Engineers Comments Regarding Surface Water Drainage

Application Reference:	R/93/25/DOC	Reviewer Reference:	ADC/EXT2/D2134/78
Planning Officer:	Simon Davis	Date of Review:	03.09.2025
Site Name:	Rustington Convalescent Home Sea Road Rustington BN16 2LZ		
Application Description:	Approval of details reserved by condition imposed under reference R/258/18/PL relating to condition number 19 - foul and surface water sewerage disposal.		
Assessment Number:	1 of 2

Condition 19: **Further information required**

1. THIS DRAWING IS TO BE READ WITH INFOGRAJRAJGE MODEL PRINTOUT 25-043 See
Road, Rustington, SW System' DATED 15-05-2025.

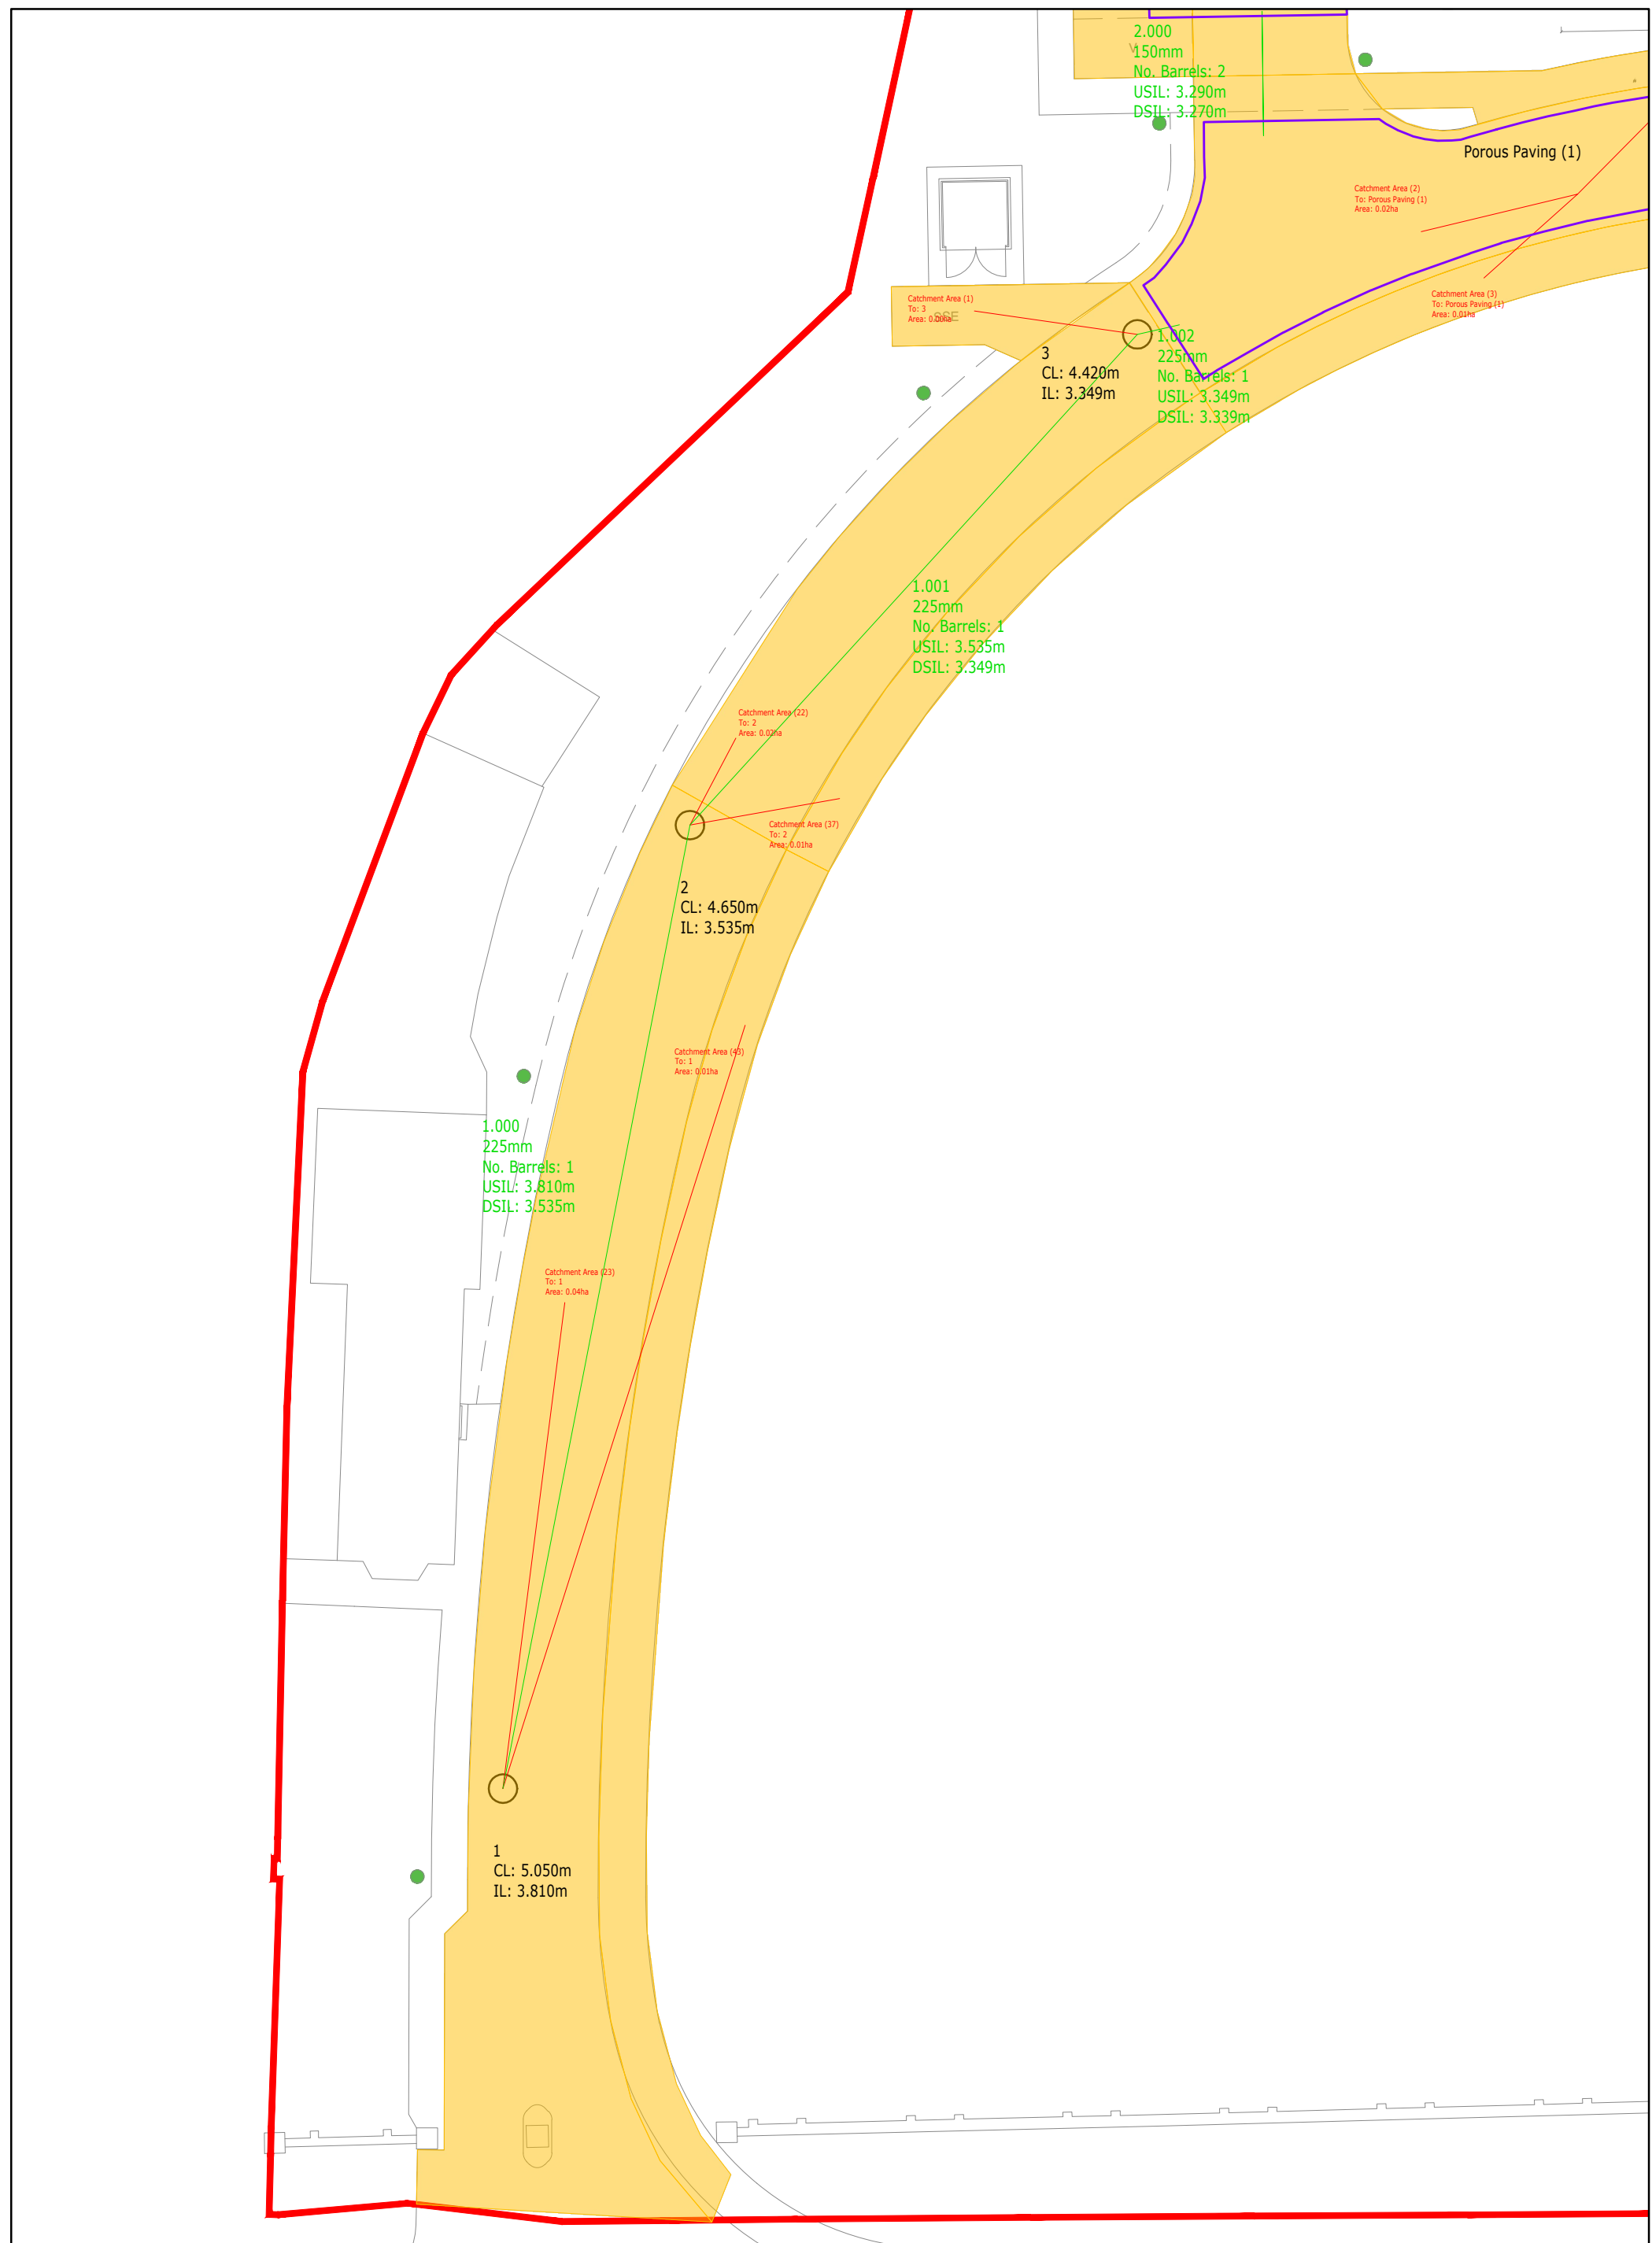
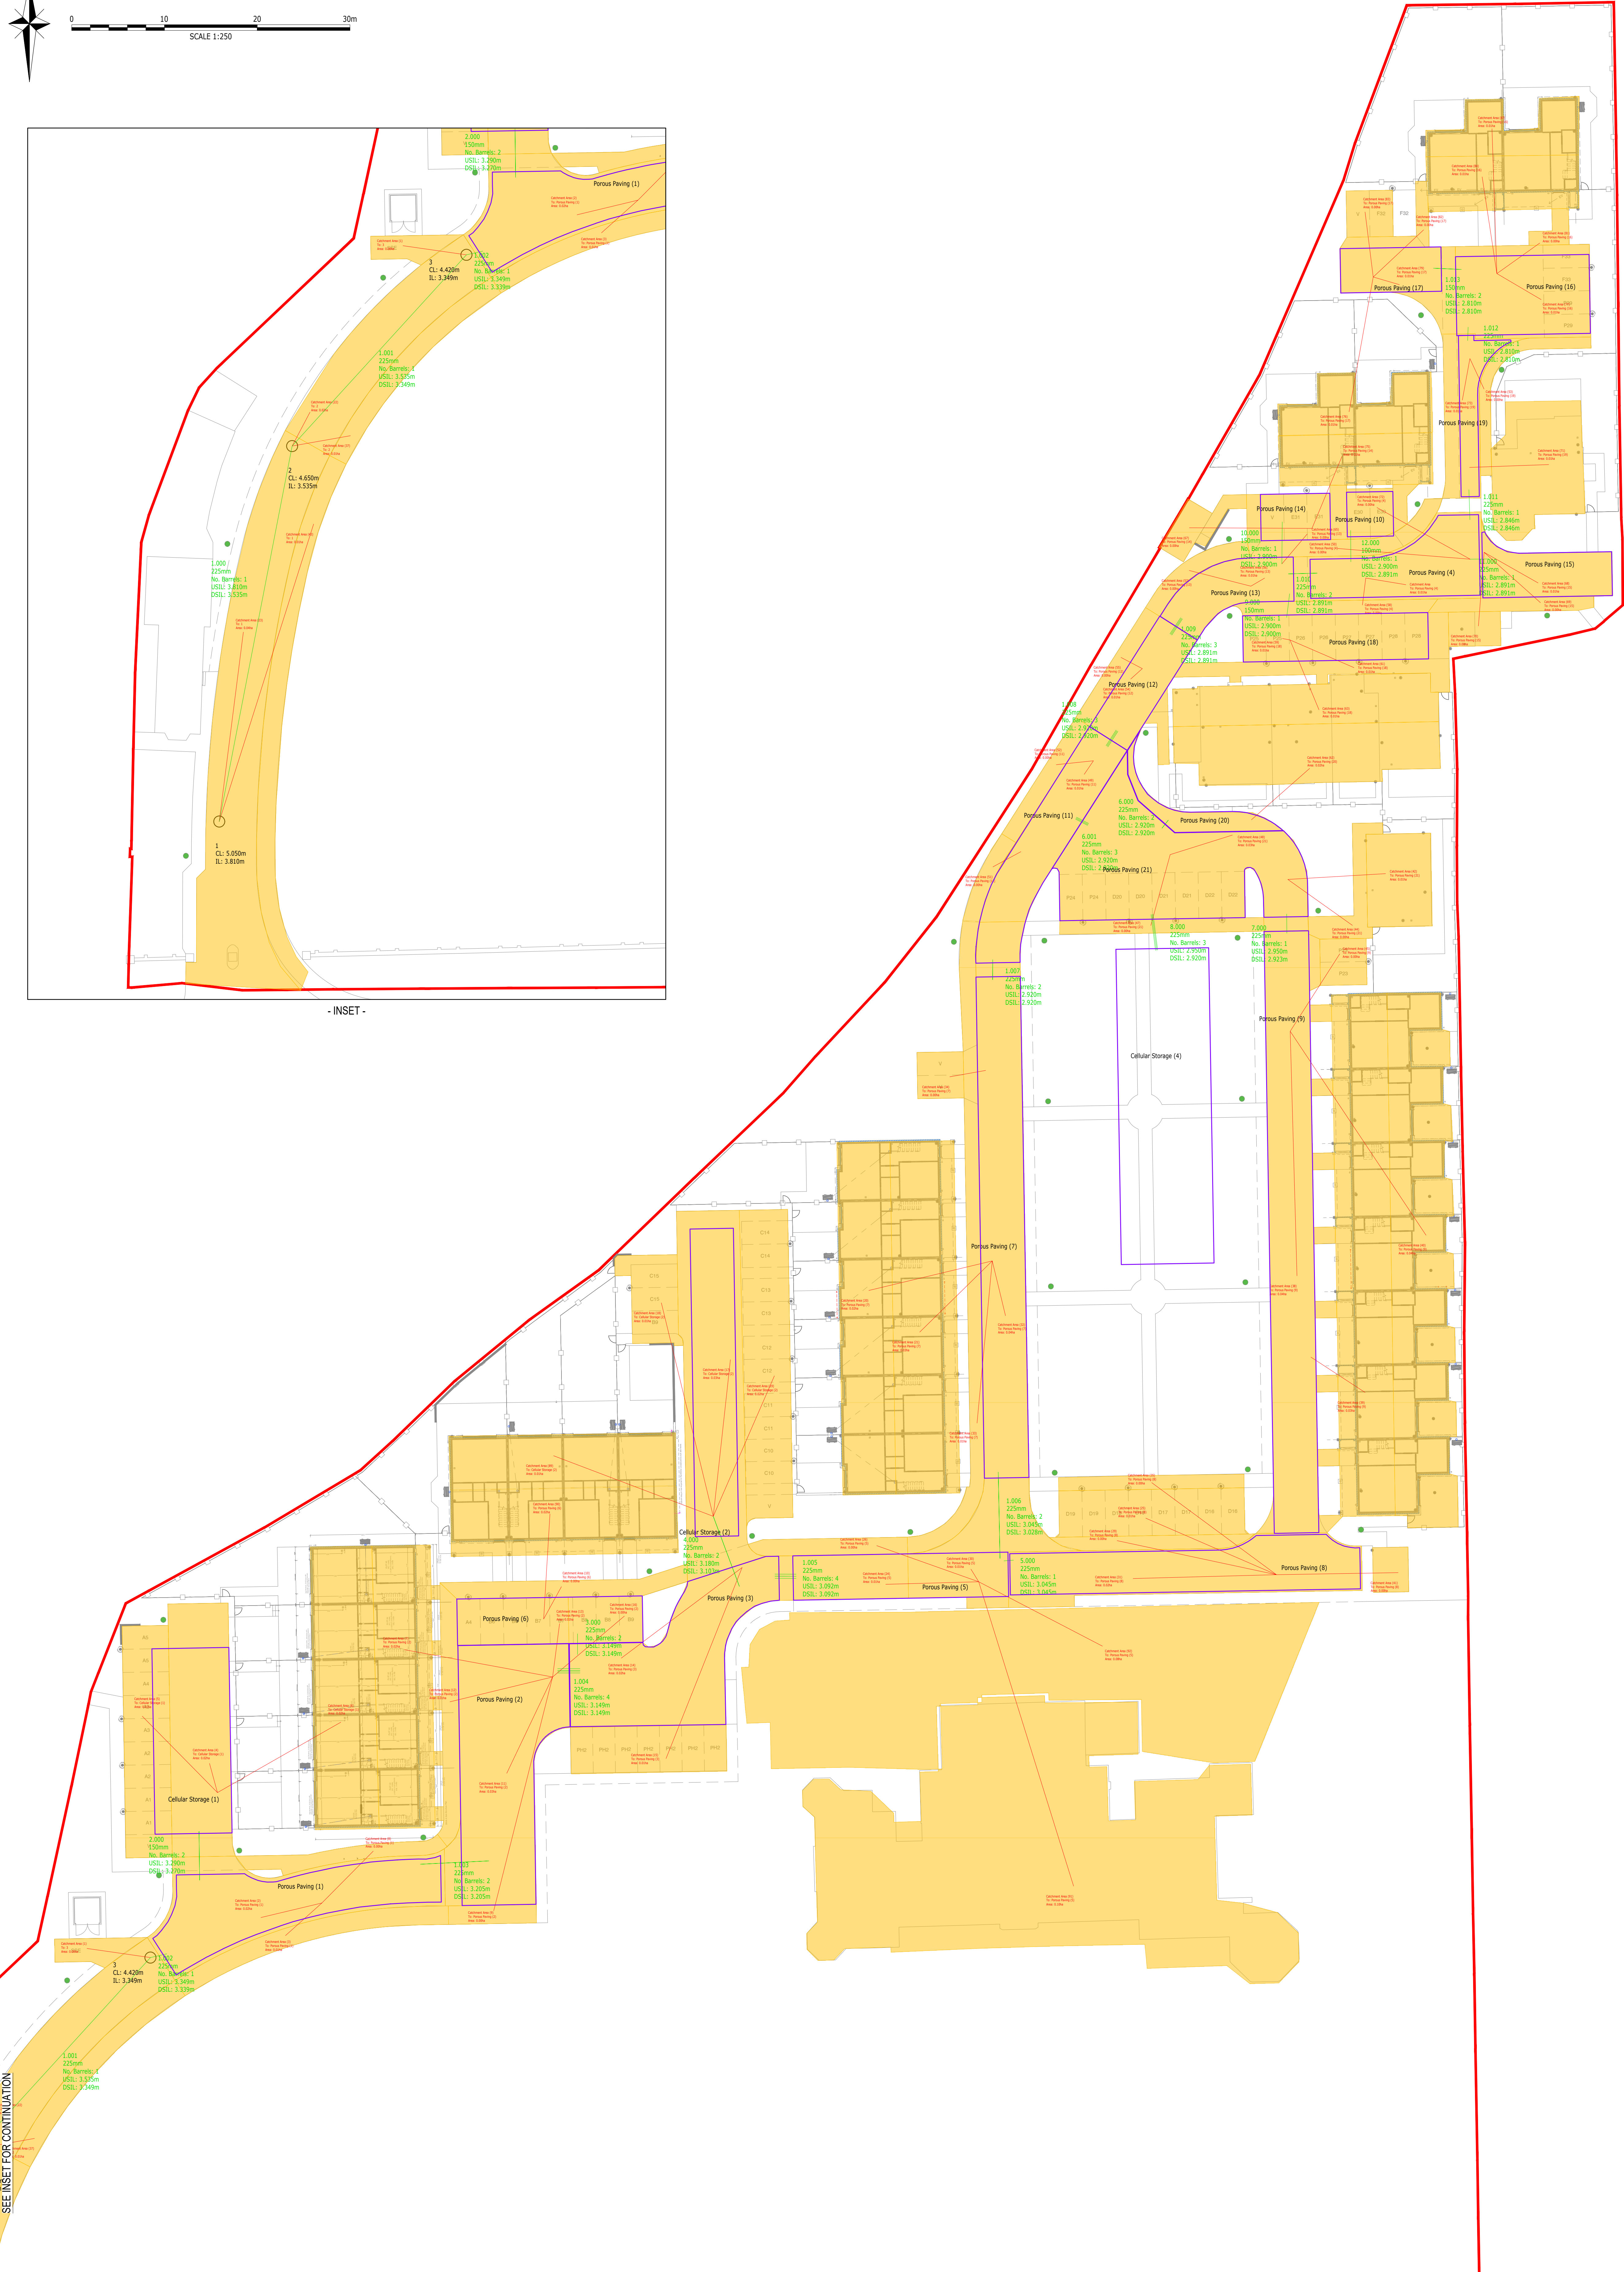
13.	ADC Drainage Comments 28/02/2024: The 1D model must include a supporting plan to denote all nodes/links or cascade approach. Designer Response 25/06/2024: See Drawings. ADC Drainage Comments 31/07/2024: The drainage strategy plans and Infodrainage calculations do not tally. There are numerous catchment areas not identified on any plans. Comment outstanding. Designer Response 18/08/2024: Refer to Infodrainage calculations '24-059 - Rustington, Sea Road_SW system' including the catchment plan which provides the requested information. ADC Drainage Comments 28/10/2025: The drainage strategy plans and Infodrainage calculations do not tally. There are numerous catchment areas not identified on any plans. Comment outstanding.	Infodrainage model checked and all catchments updated. Please refer to drawings 25-043-151 and 25-043-152 and Infodrainage 25-043 Sea Road, Rustington_SW System printout for the details of catchments used in the model.	With reference to the 1D calculations and drawing 25-043-152A, it remains unclear what areas have urban creep applied. Furthermore urban creep is not mentioned in the technical note. Comment outstanding.

Comment outstanding.				
17.	ADC Drainage Comments 28/02/2024: There is no drawings to demonstrate the existing and/or proposed impermeable area comparison and denote each catchment area to support the calculations areas. Designer Response 25/06/2024: See Drainage Strategy Drawings. Designer Response 18/08/2024: Whilst no comment has been made, the proposed design is supported by the Infodrainage calculations '24-059 - Rustington, Sea Road_SW system' including catchment plan that demonstrates connectivity of each sub-catchment into the respective part of the system. ADC Drainage Comments 28/10/2025: The key plan on page 1 of the calculations is illegible and does not quantify the catchments.	Please refer to drawing 25-043-152 that details catchments used in the model.	Comment closed.		
	Drainage & Maintenance Manual:
